El Paso County Planning and Community Development

Re: Falcon Marketplace Preliminary Plan (SP-17-001) Response 6

Please accept this response letter to your review 4 comments dated August 27, 2018.

EXISTING DRAINAGE CONDITIONS

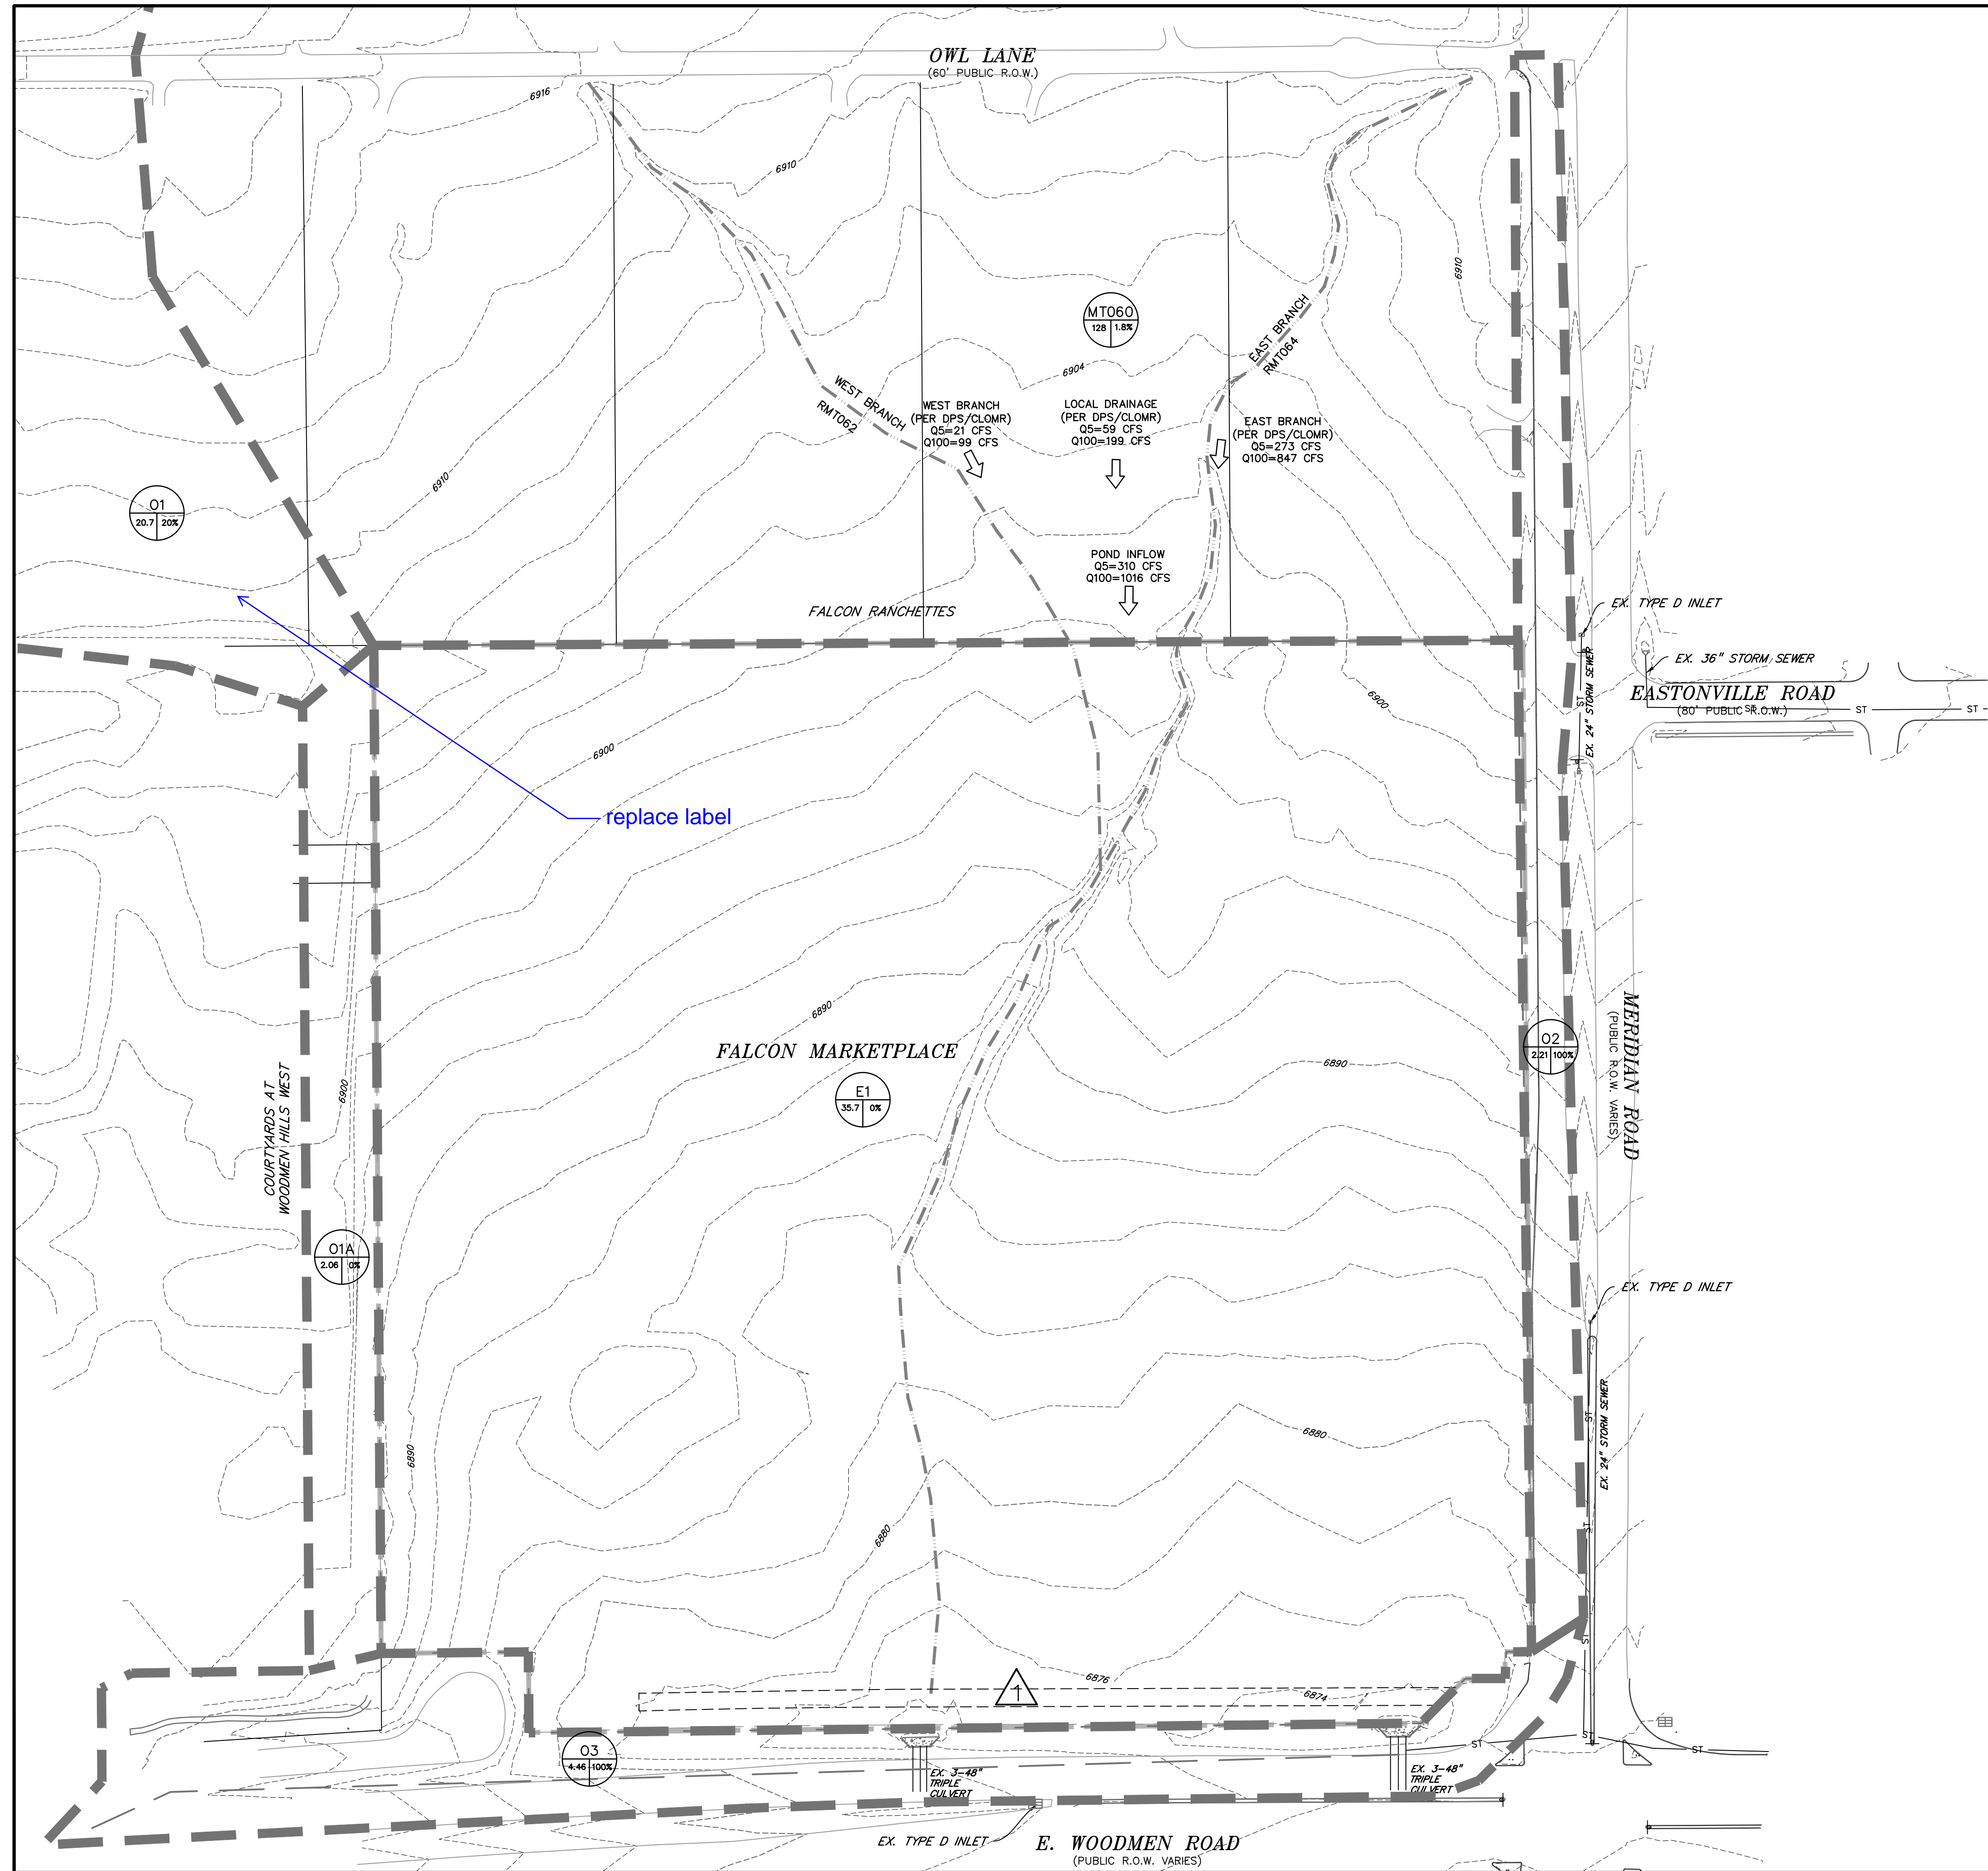
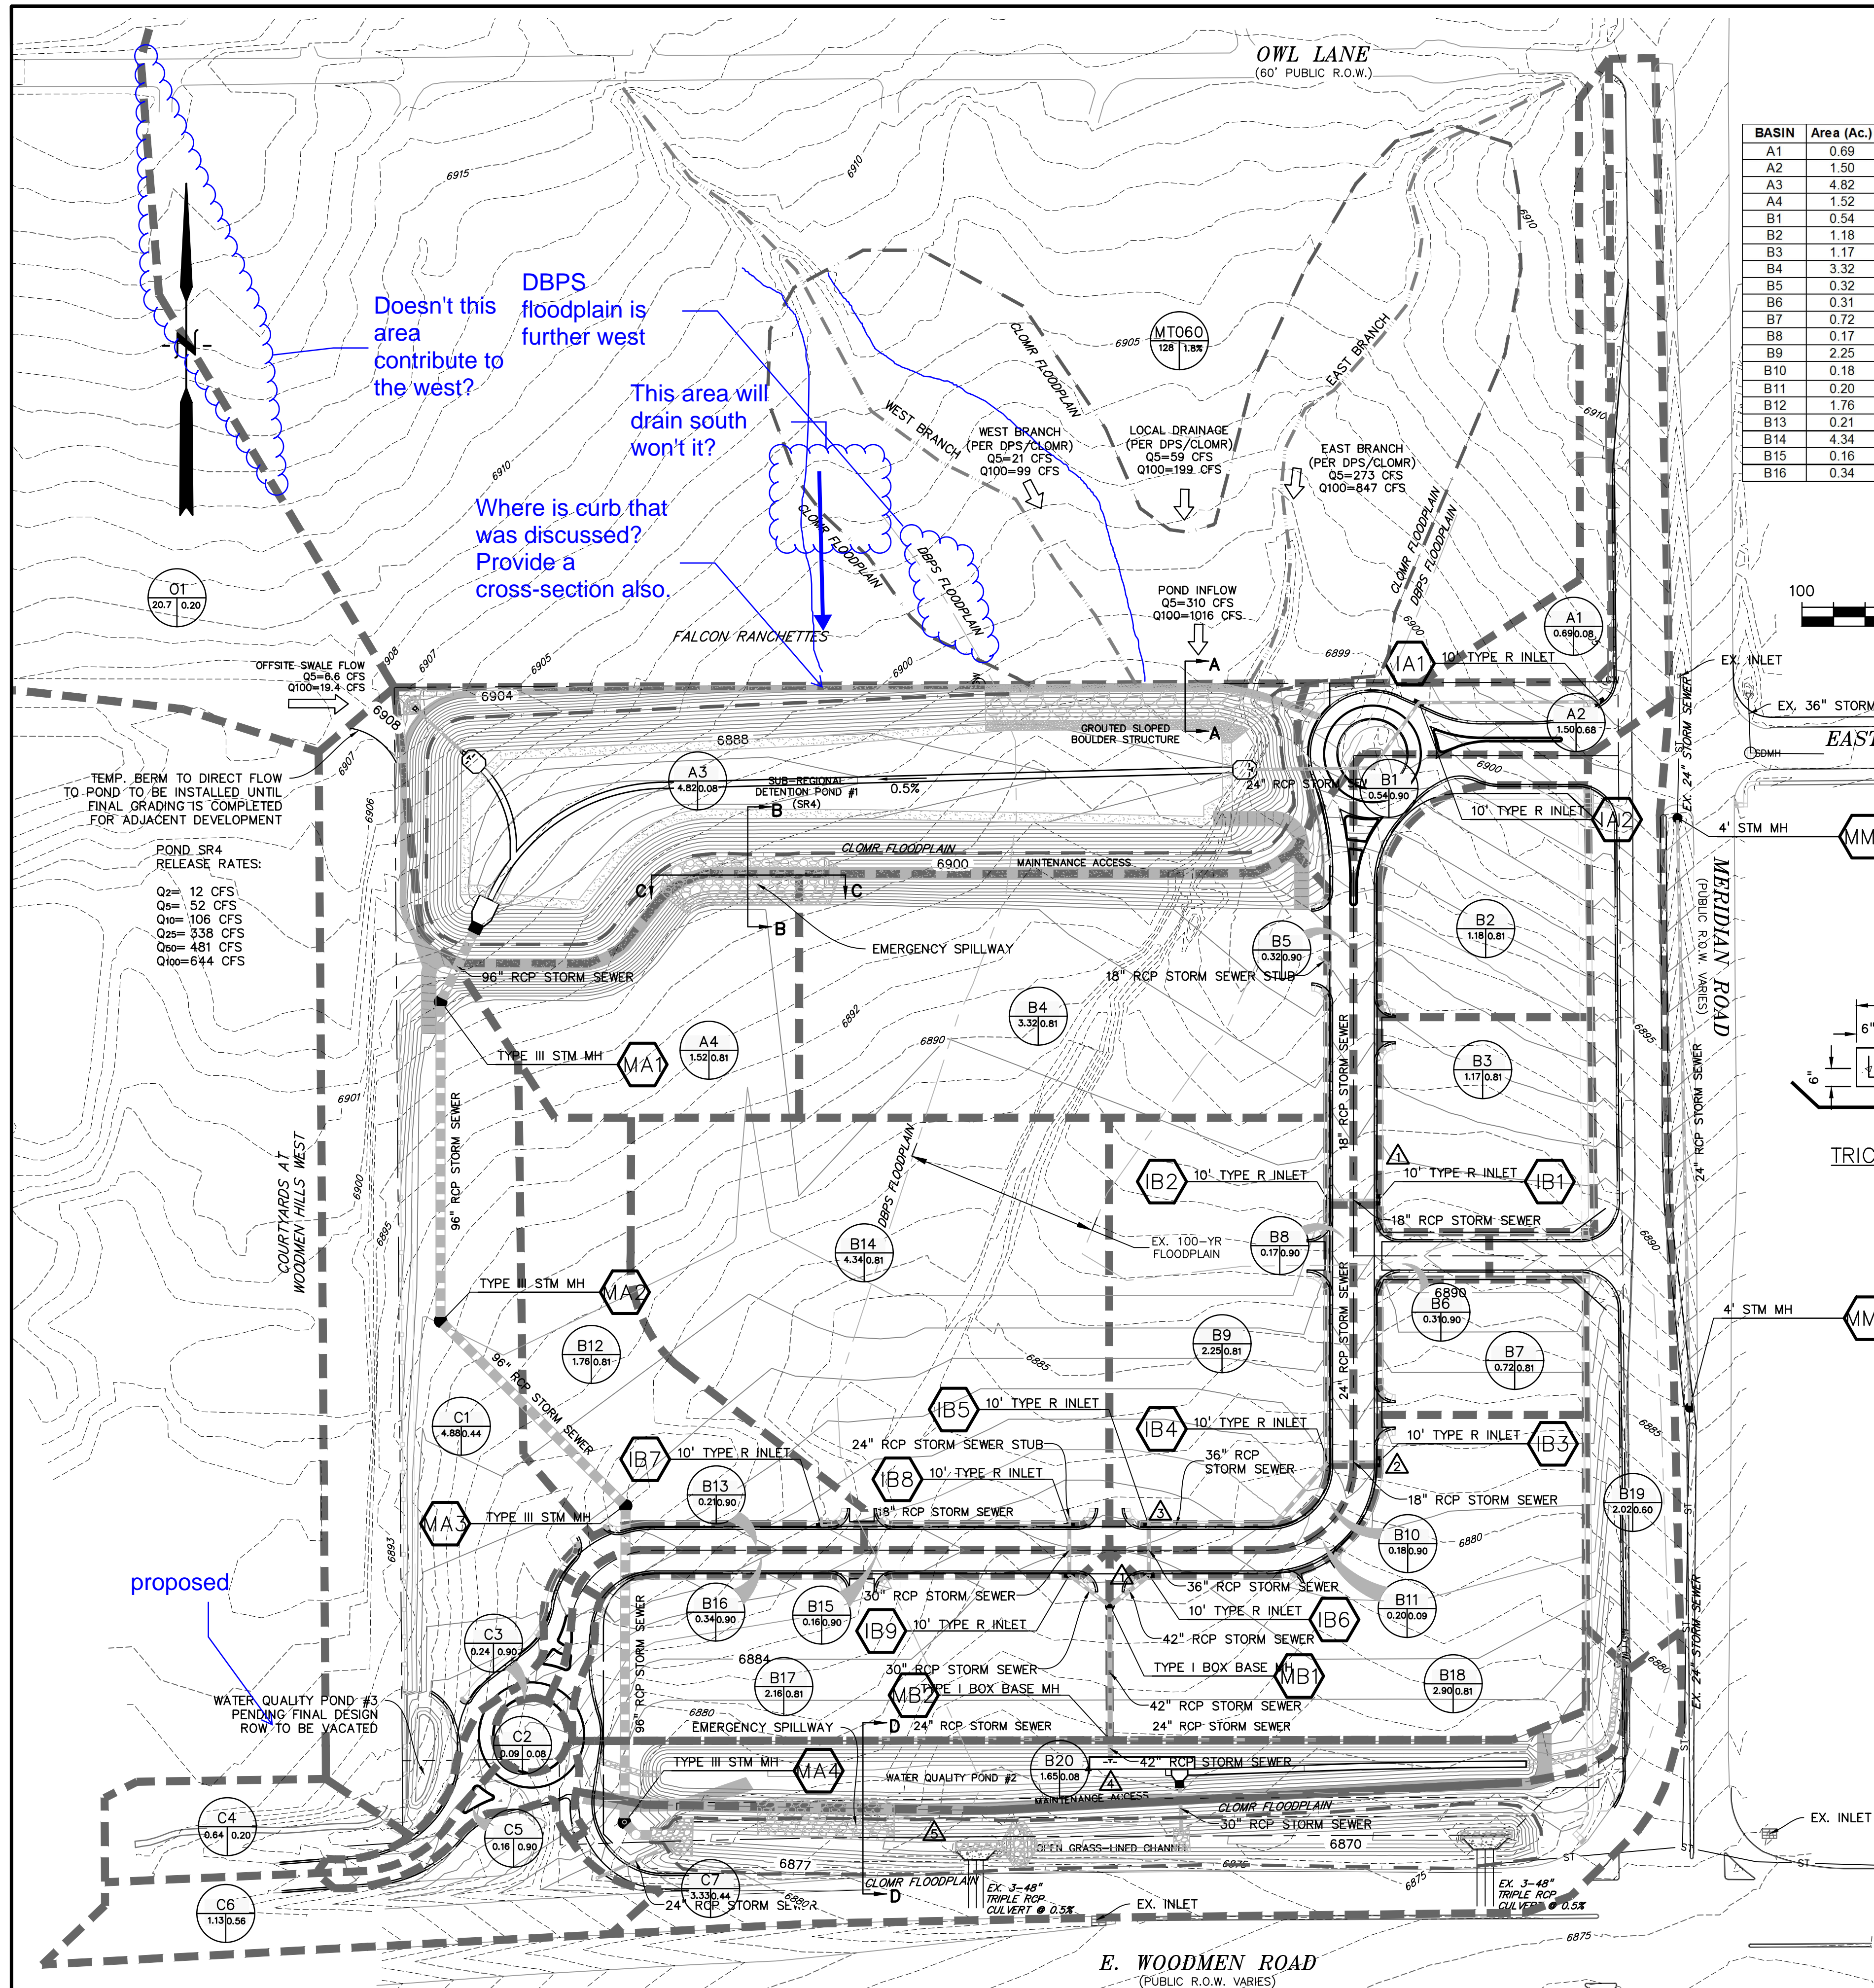
- a. Resolved.
- b. **Resolved.**
- c. *Resolved*
- d. Provide a design point summary of 5- and 100-year flow rates at all surface and pipe design points on both the existing and proposed plans. Partially resolved; address per local basin and DP redlines. *Comment remains; see redlines regarding flows from the north. Comment remains.* Unresolved. **Unresolved. Additional basin added for the area north of the development to the west. PDR and plan sheet updated accordingly.**
- e. *Note: The determination of crown location and inlet or sheet flow for the additional paving on Meridian Road (and at other offsite locations if required due to approval of the Woodmen Road right-in) will need to be determined with the Final Drainage Report and offsite CDs.*
